DATE: 07/08/2015

**SUBJECT: LU/228/15/PL - Conversion of ground and first floor at the rear into two 2 bedroom flats.
resubmission of LU/71/15/PL**

SITE PLAN

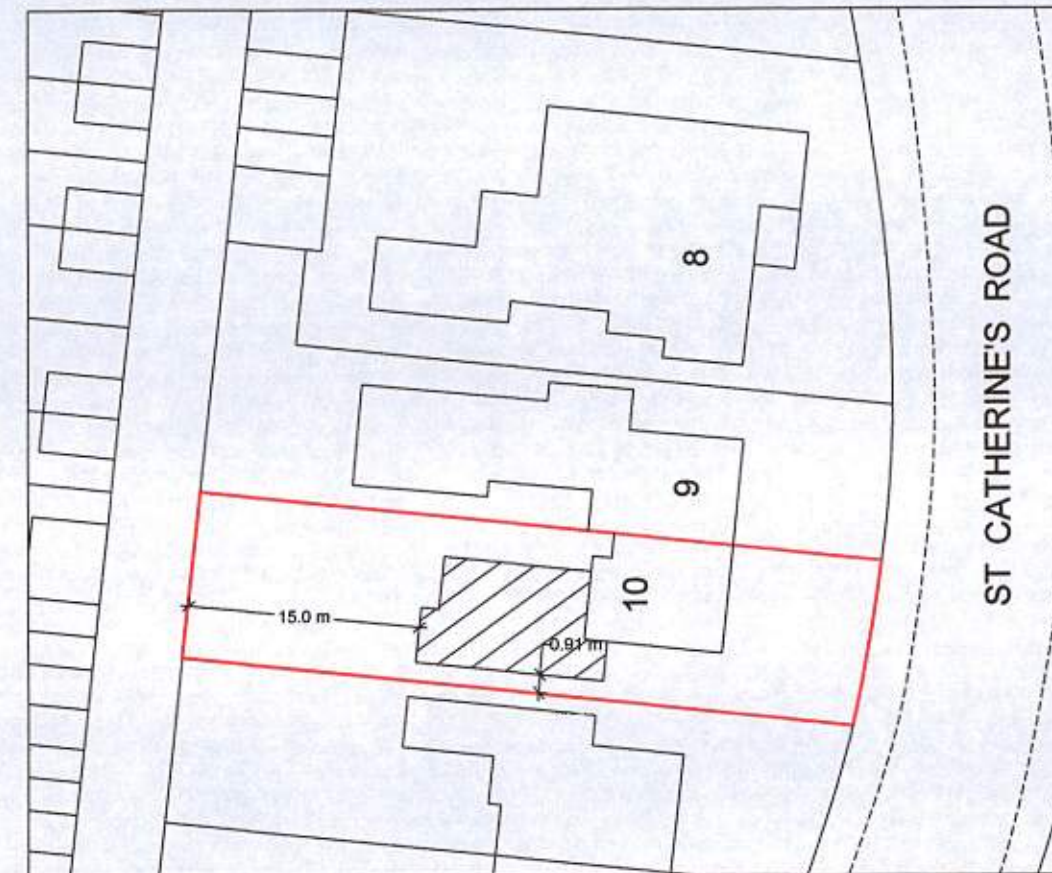
No details of the site parking provision have been provided. From a desktop study it would be anticipated that the existing site parking provision could provide 2 off street car parking spaces while maintaining a turn on site or 3 spaces without a turn on site.

While I do not believe any on street car parking demand created by this proposal would result in a highway safety issue the LPA would be advised to consider the implication this development would have towards on street car parking. The LPA would be advised that WSCC would anticipate two flats and a house (existing) of this size in this location would be anticipated to attract the demand for 3 vehicle car parking spaces, if unallocated.

An appropriately sized, communal or independent, secure and covered cycle parking provision should be provided in the interests of sustainability. This provision should be secured via condition with plans and details submitted to and approved by the Local Planning Authority.
